Consultation Response from: KC Environmental Health (Pollution & Noise Control)
2023/92145 - East Bierley Playing Fields, Hunsworth Lane, East Bierley, BD4 6PU

Discharge of conditions 5 (access track upgrade), 6 (access track upgrade), 7 (cycle parking), 8 (electric vehicle charging), 9 (travel plan), 10 (waste storage and collection), 11 (coal mining investigation), 16 (Japanese Knotweed strategy), 17 (external lighting), 29 (part) (landscaping) and 30 (biodiversity enhancement and management plan) of previous permission 2021/90357 for works to existing sports facilities including erection of clubhouse; additional changing facilities building; boundary treatments; storage facilities and floodlighting; works to existing pitches creation of hybrid and 3G/synthetic pitches; multi sport training area and car park

Date Responded:
4th September 2023
Responding Officer:
NH
Responding Ref:
WK/202324020

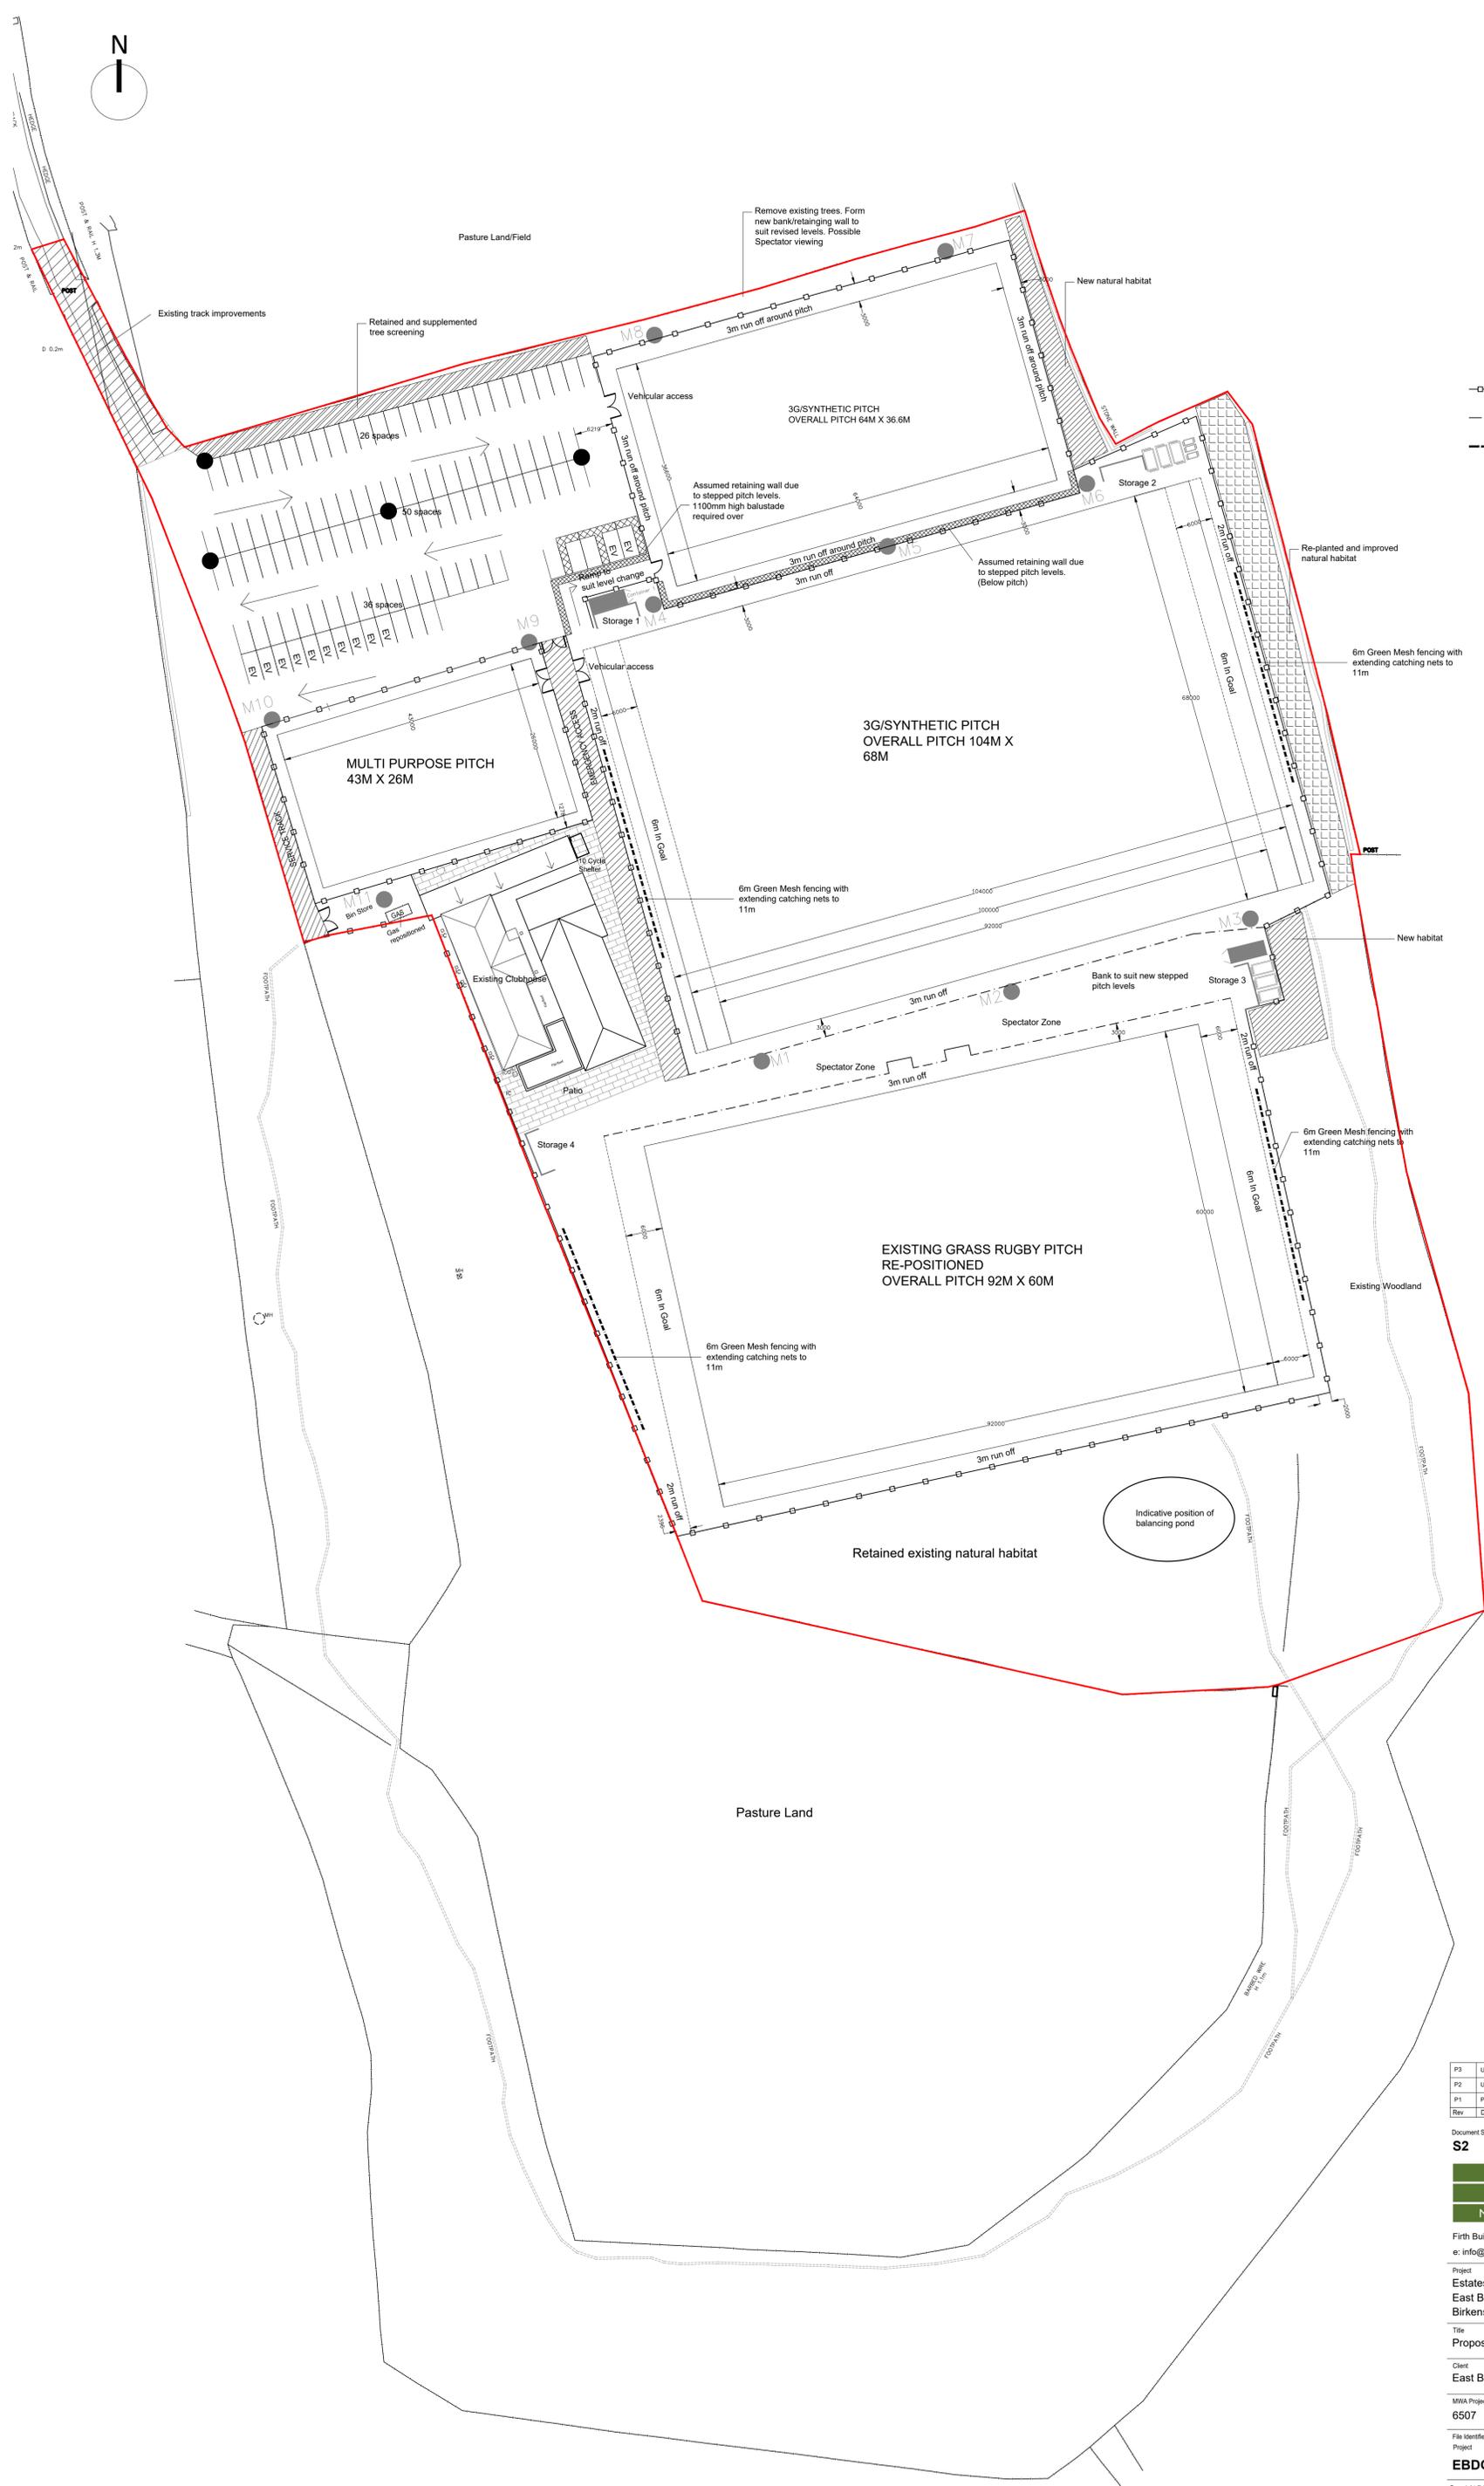
A drawing by Martin Walsh Architectural dated 22nd May 2023 (ref: EBDC-MWA-XX-XX-DR-A_0001_P5) has been received in support of the application to discharge Condition 8. The drawing shows the locations of the proposed EV charging bays. A total of 12 EVCPs are to be installed. This meets the requirements of the condition. The plan also confirms the charging points will meet the minimum output of 16A/3.5kW requirement as mandated by the condition.

We accept the drawing by Martin Walsh Architectural dated 22nd May 2023 (ref: EBDC-MWA-XX-XX-DR-A_0001_P5). However, Condition 8 must remain until the EVCPs are installed and made operational.

3.5 Horizontal Spill: Iso Contour

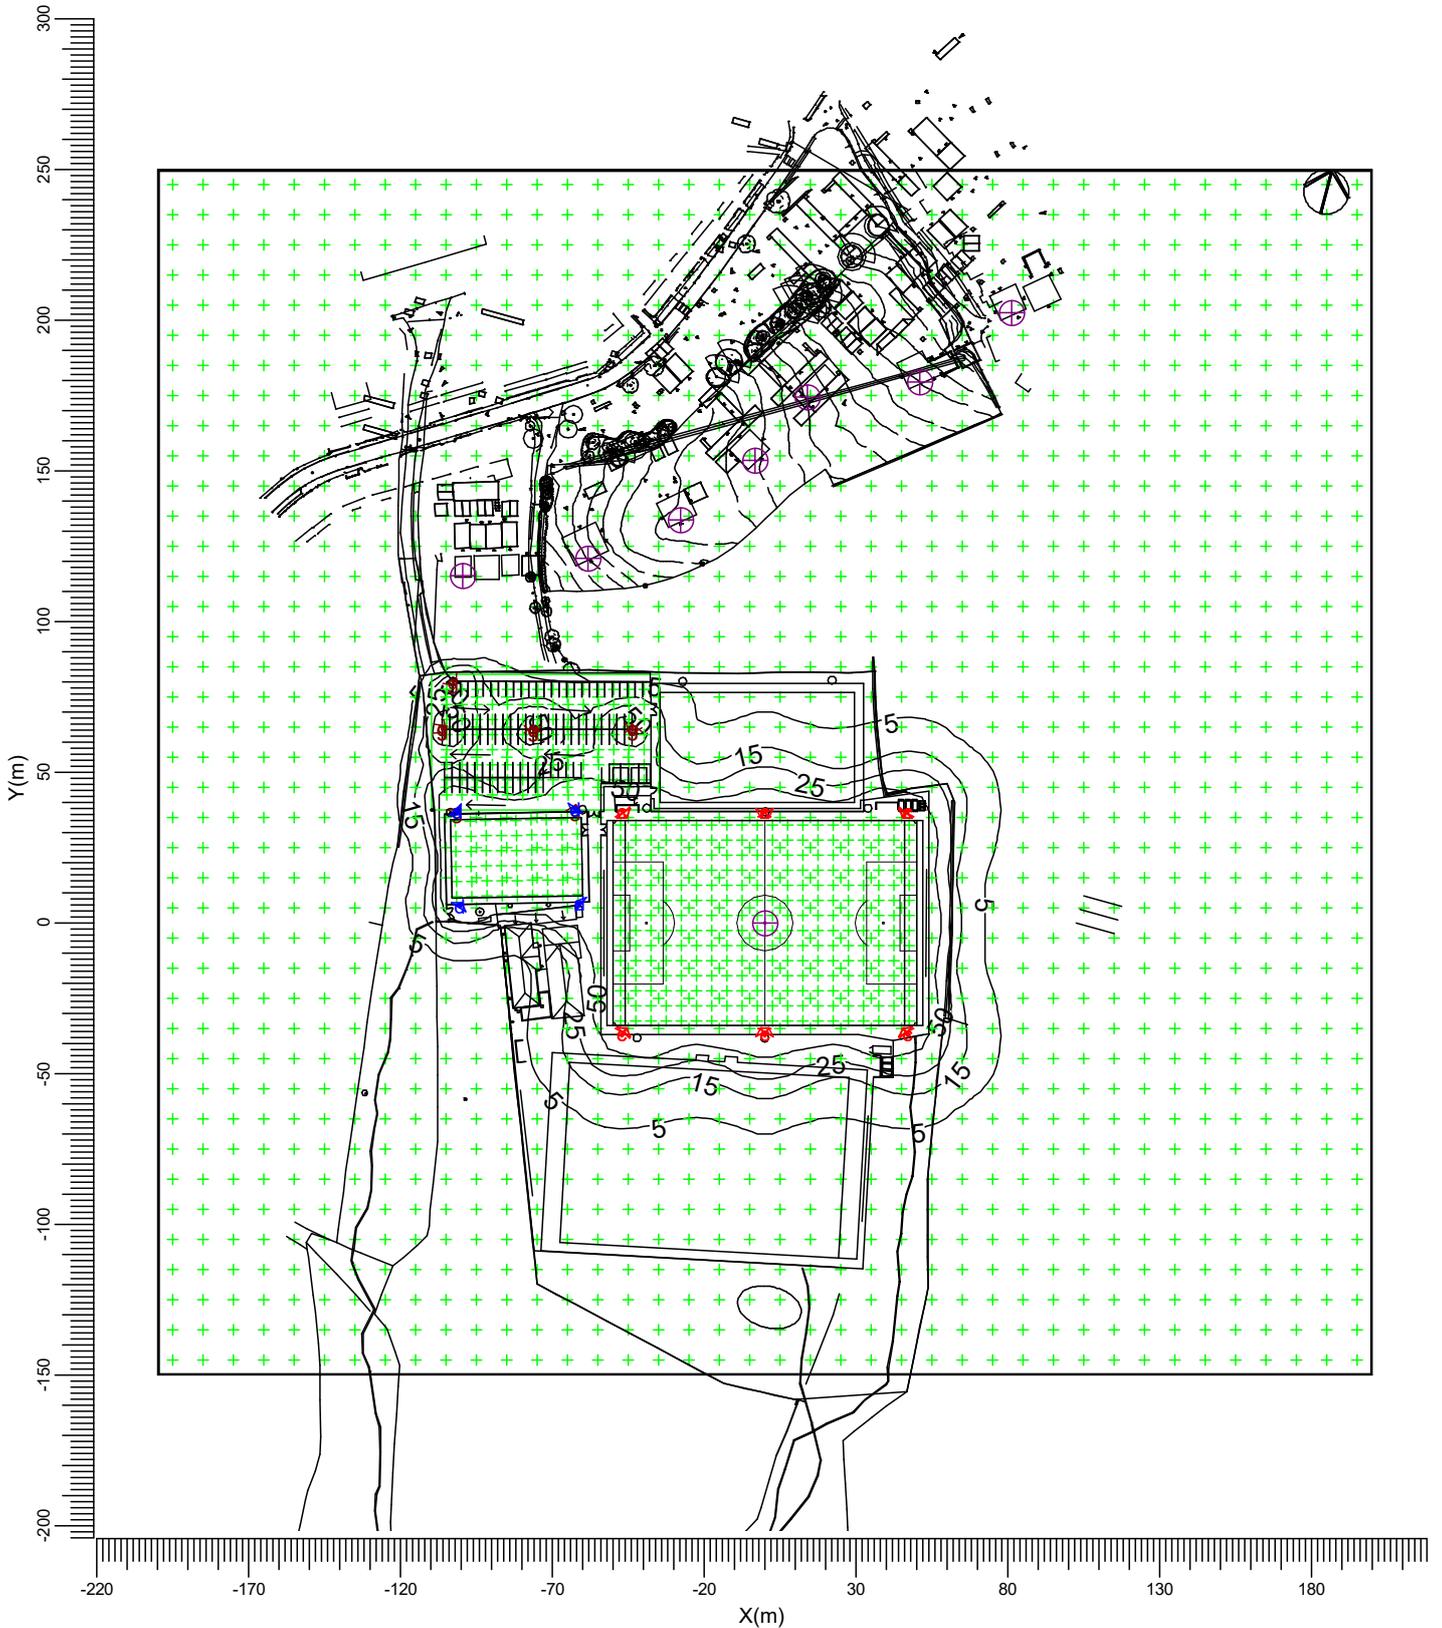
The proposals include the installation of 16 luminaires to serve the football and MUGA pitch. The horizontal spill shows that at the perimeter of the site, surface illuminance will be ≤5 lux. The vertical illuminance at 3m shows a peak illuminance of 613.1 lux.

Overall, we accept the external lighting scheme dated 22nd March 2023 authored by Halliday Lighting and a document titled 'Discharging of Conditions relating to Approval 2021/62/90357/E. Set 1' authored by Martin Walsh Architectural, dated 15th May 2023 (ref: EBDC-MWA-XX-XX-RP-A-0001). Condition 17 should be discharged.
